**KIRKLEES METROPOLITAN COUNCIL  
INVESTMENT & REGENERATION SERVICE**

**DELEGATED DECISION TO DETERMINE PLANNING APPLICATIONS**

Reference No:	<b>2023/62/93751/W</b>
Site Address:	Land rear of, 225, Lockwood Road, Lockwood, Huddersfield, HD1 3TG
Description:	Erection of one shop unit with associated parking, bin storage area and alterations
Recommending Officer:	Lucy Taylor

**DECISION – REFUSED**

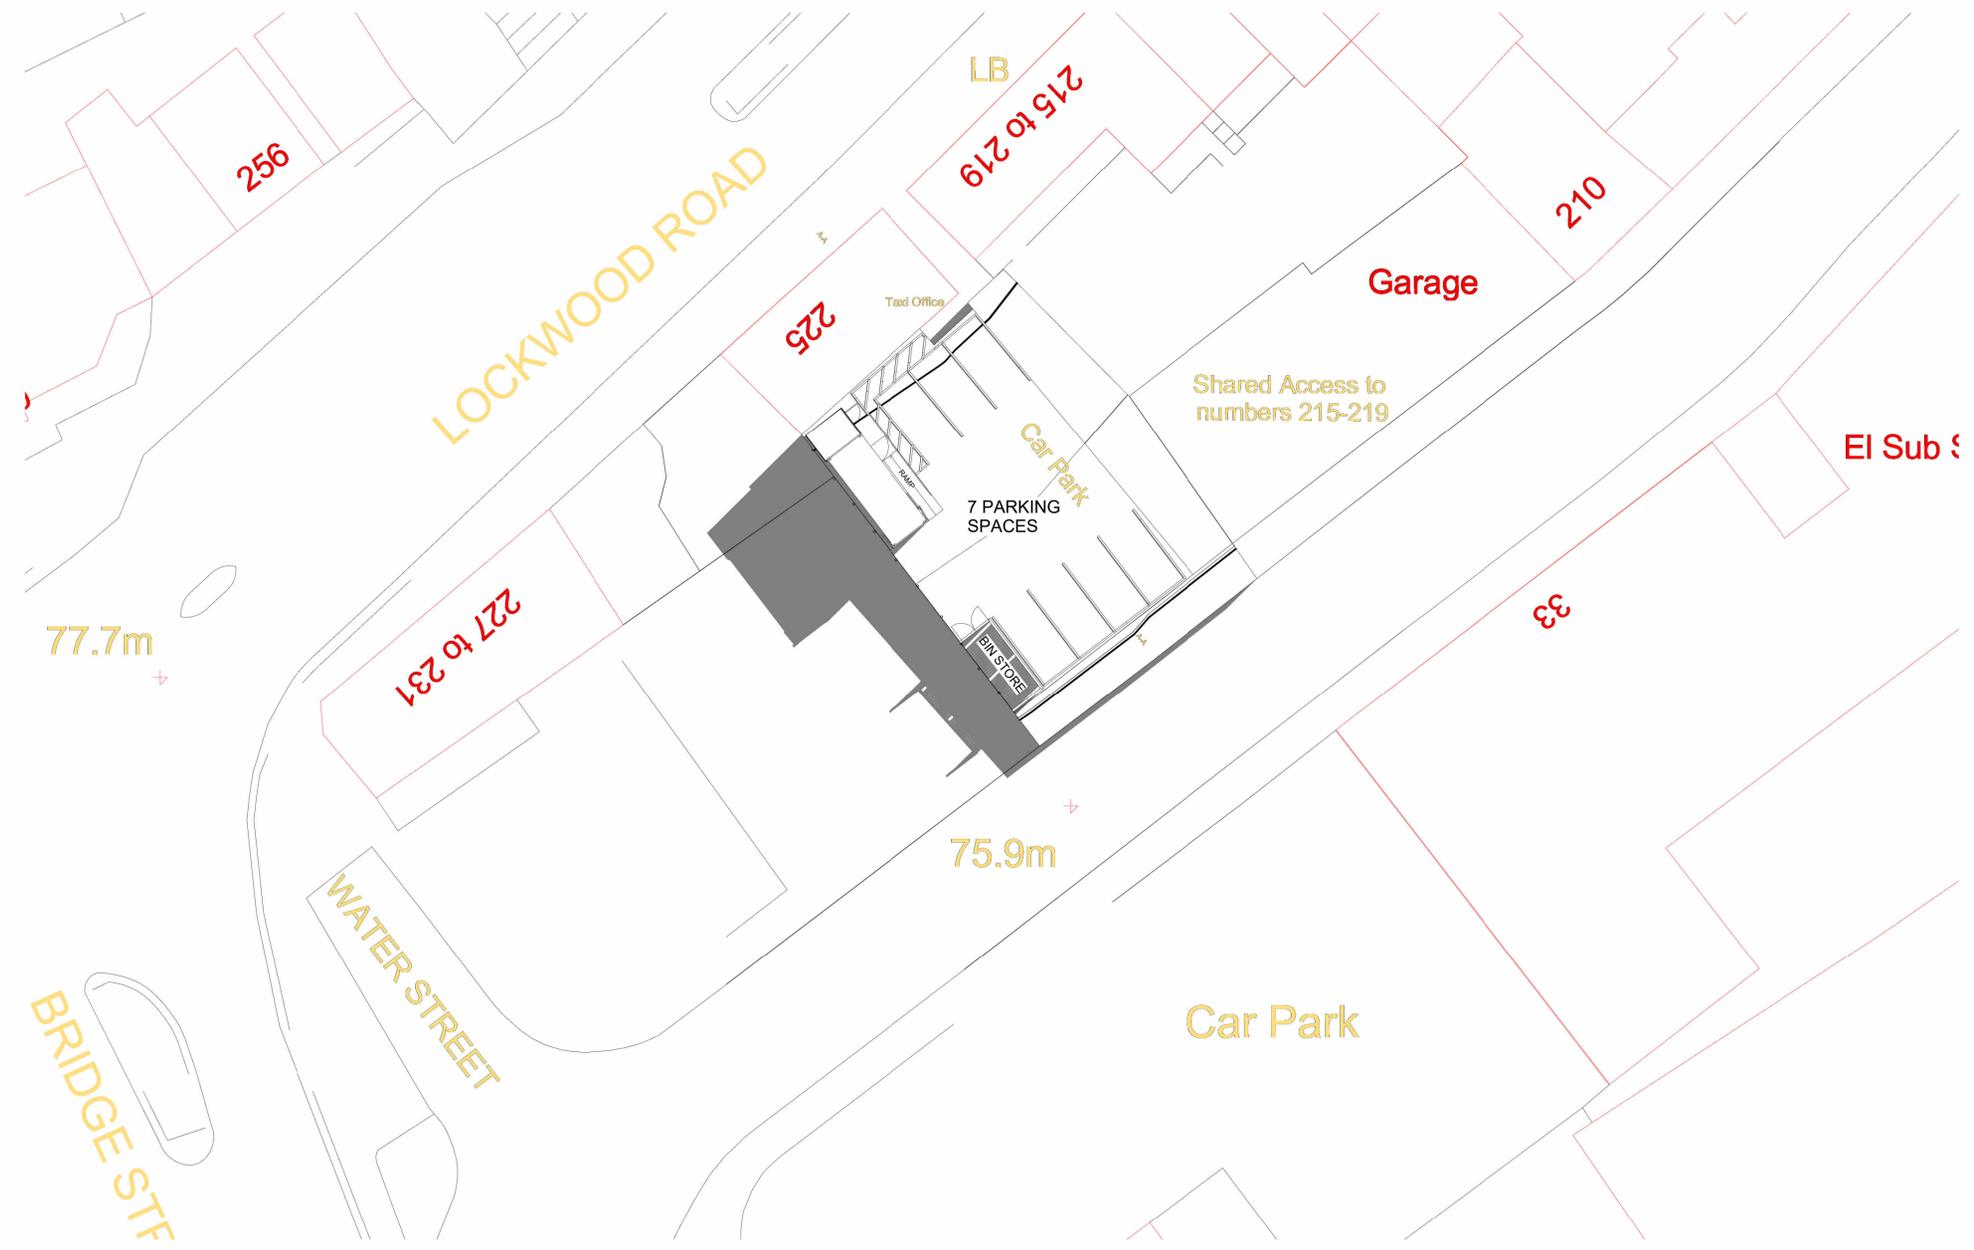
The shop unit would have a width of 8.3 metres (front & rear elevations) and a depth of 3.2 metres (side elevations) (3.5 metres including ramp). The maximum height of the unit would be 2.6 metres.

The unit would be a recycled shipping container, with glazing installed to the north east facing front elevation and south east facing side elevation.

Seven parking bays are shown on the submitted plan in a reconfigured arrangement.

A bin store is to be erected in the corner of the car park.

In this case, the container is to be situated on an area of hardstanding, currently free of any built form due to its use as a car park for the nearby commercial buildings and operations. The container is considered to appear functional and utilitarian in appearance. As such, is considered that the container would detract from the character and appearance of the area, as it would fail to be in keeping with the existing built form of the area and would lower the quality of the built environment. If approved, the works would create an undesirable precedent, with development based only on functionality.

The site's current open nature further adds to the concern raised above, as the development would be readily visible from multiple public vantage points. Therefore, given its functional form and utilitarian appearance and design, the repurposed storage container and accompanying bin store, are considered unsightly and bulky within the local context, failing to respect the current built form. In addition, whilst the finish of the container has not been specified, it would not be in keeping with the predominant local material, which appears to be stone. It should be noted that, even if it were to be finished in a 'stone' colour, this would not overcome the harm from the siting, form and appearance of the structure. The proposal would therefore fail to comply with paragraph 135 of the NPPF.

Notwithstanding this, the development by combination of its siting, scale, utilitarian appearance and functional design and materials would not promote good design and would cause detrimental harm to the visual amenities of the locality, thereby failing to comply with Policy LP24 of the Kirklees Local Plan and Chapter 12 of the NPPF.

Furthermore, it is not clearly demonstrated that waste storage facilities would not impact upon visual amenity of the locality and as such reason 6 of the previous refusal is not, therefore, considered to have been overcome in this regard.

It is proposed access to the site would be via one existing singular point of access off Albert Street, which is shared with adjoining properties/businesses. On site observations indicated that the existing car park is predominantly at capacity, with it assumed that parking is currently taken up by customers to the shop and taxi business underneath. No information has been provided as part of this application regarding the displacement of the existing parking provisions.

No information has been supplied regarding how the existing business's receive deliveries. The proposed plan appears to allow limited space for delivery vehicles to enter and exit the site in forward gear or any turning space. Waste collection details, including whether waste collection vehicles could access the site, have not been provided. Given this, it appears this will

block the existing shared access to both the car park and adjoining businesses/properties.

The submitted floor plan demonstrates that a WC is to be included within the unit, and therefore there is an expectation for a sink to also be installed. No information has been provided regarding the safe disposal of foul water from the premises. Upon formal consultation with KC Environmental Health, Environmental Health officers noted that this information should be provided before the application is determined, with the applicant required to demonstrate an adequate system of foul water drainage.

1. The development by virtue of its siting, scale, utilitarian and functional design and materials, would result in an incongruous, undesirable and over-prominent form of development that would have a detrimentally harmful impact on the character of the site and the wider context. The proposed development would fail to promote good design, contrary to Policy LP24 (a) of the Kirklees Local Plan and Chapter 12 of the National Planning Policy Framework.

2. The proposed development would cause a loss of on-site parking at the application site, whereby no information has been submitted to show that it would not cause conflict with parking and deliveries to the existing shop, parking for the taxi business and the private access to the dwellings and businesses known as 215-219 Lockwood Road. As a consequence, this would force additional parking and waiting onto the highway known as Albert Street which would have a detrimental impact on highway safety, contrary to Policies LP16 (d and e), LP21 and LP22 of the Kirklees Local Plan, the Council's adopted Highways Design Guide Supplementary Planning Document and Chapter 9 of the National Planning Policy Framework.

3. It has not been demonstrated that waste storage or facilities for the disposal of customer's litter can be accommodated within the application site such that this can be adequately screened in a manner and location that does not detract from the street scene or the character of the area. Furthermore, given the relationship between the proposed unit and the wider car park, it has not been demonstrated that it would be possible to site waste storage facilities that would provide access for refuse collection vehicles. Therefore, the application would be harmful to visual amenity and highway safety contrary to Policies LP21 & LP24 of the Kirklees Local Plan and policies contained within Chapters 9 and 12 of the National Planning Policy Framework.
